Application for a Non-Material Amendment Following a Grant of Planning Permission

Householder Application - Erection of 1.5 storey side and rear extension and first floor extension to bungalow. Raise roof level with alterations to fenestration including 3no dormers to front elevation.

DC/22/03656

Title: Proposed Ground Floor, First Floor and Roof Plan

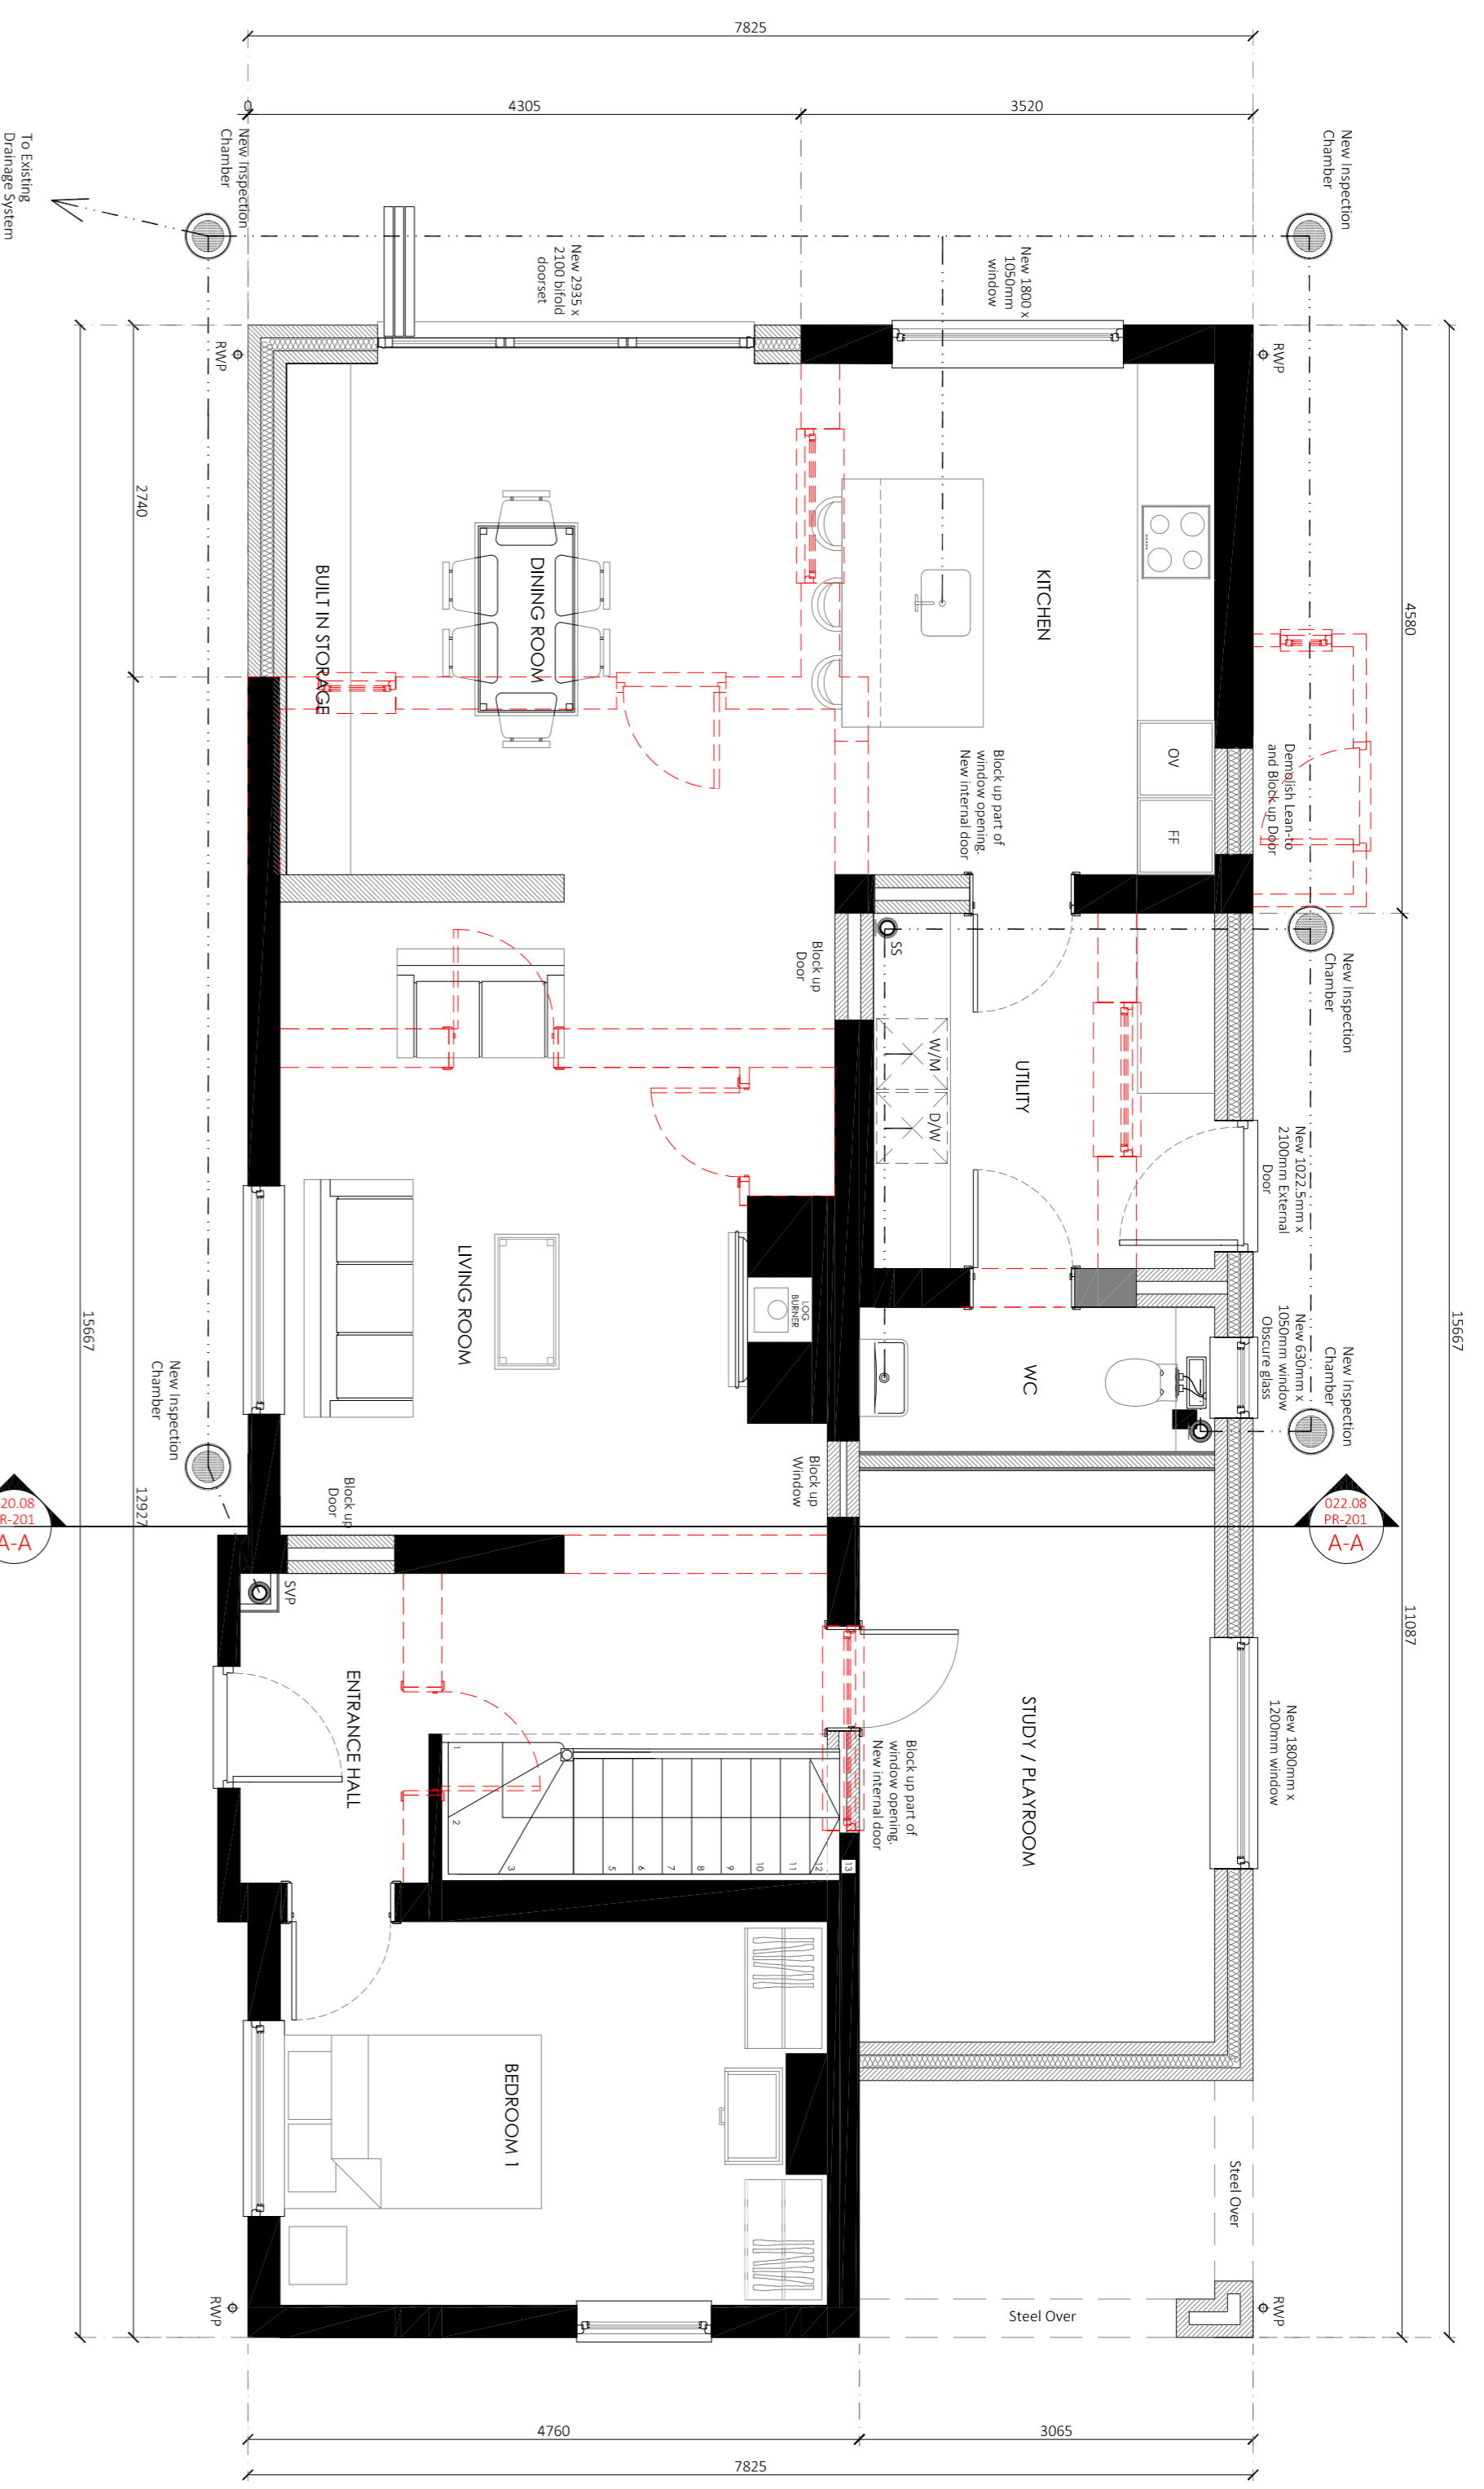
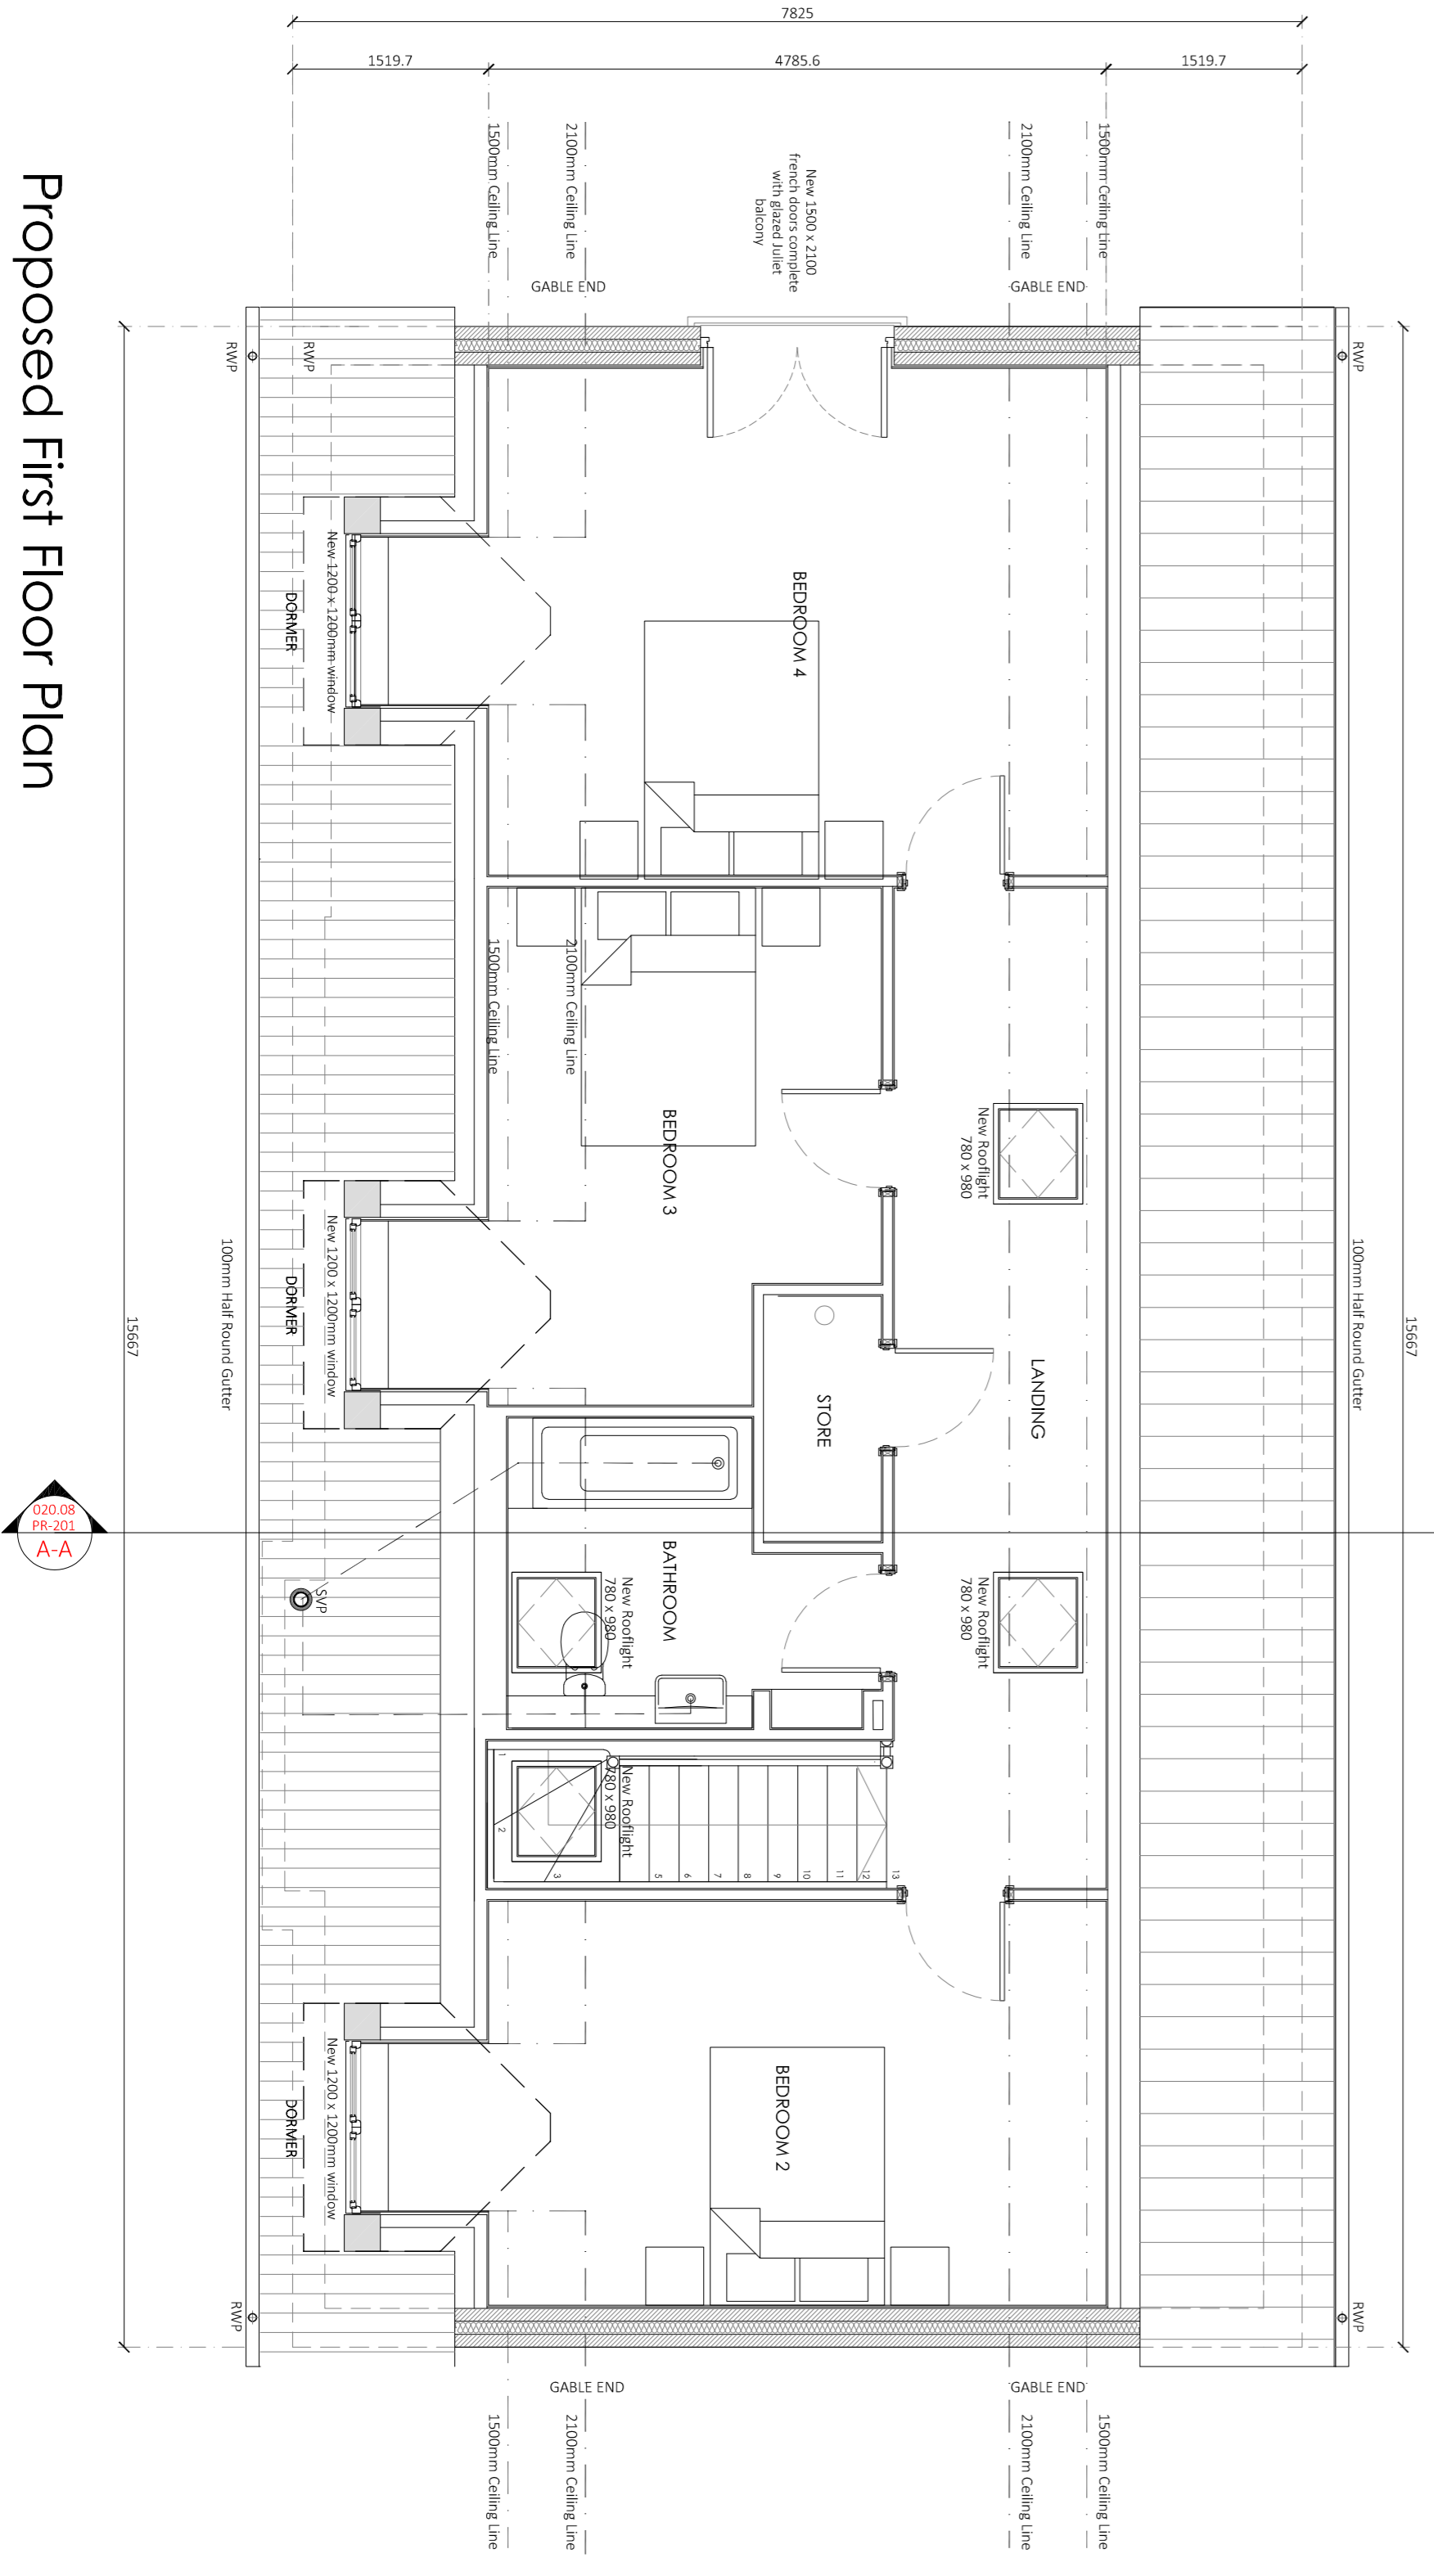
Ground floor amendments comprising minor alterations to internal kitchen, dining and utility arrangement.
First floor amendments; Bedroom 4 replaced with 1500 x 2100 french doors complete with glass Juliette balustrade.
Roof Plan no amendments.
North Elevation (Front) no amendments.
West Elevation (Side) no amendments.
South Elevation (Rear) 3 pane sash window removed, 2 Pane sash window replaced with rear door to Utility.
East Elevation (Side) Window and door configuration at ground floor adjusted to suit internal layout, 2 Pane double door replaced with 3 pane sliding patio doors. At first floor 2 pane ssh window replaced with 1500 x 2100 french doors complete with glass Juliette balustrade.
Landscaping adjusted to provide hard landscaping to new rear access door.
Section A-A no amendments
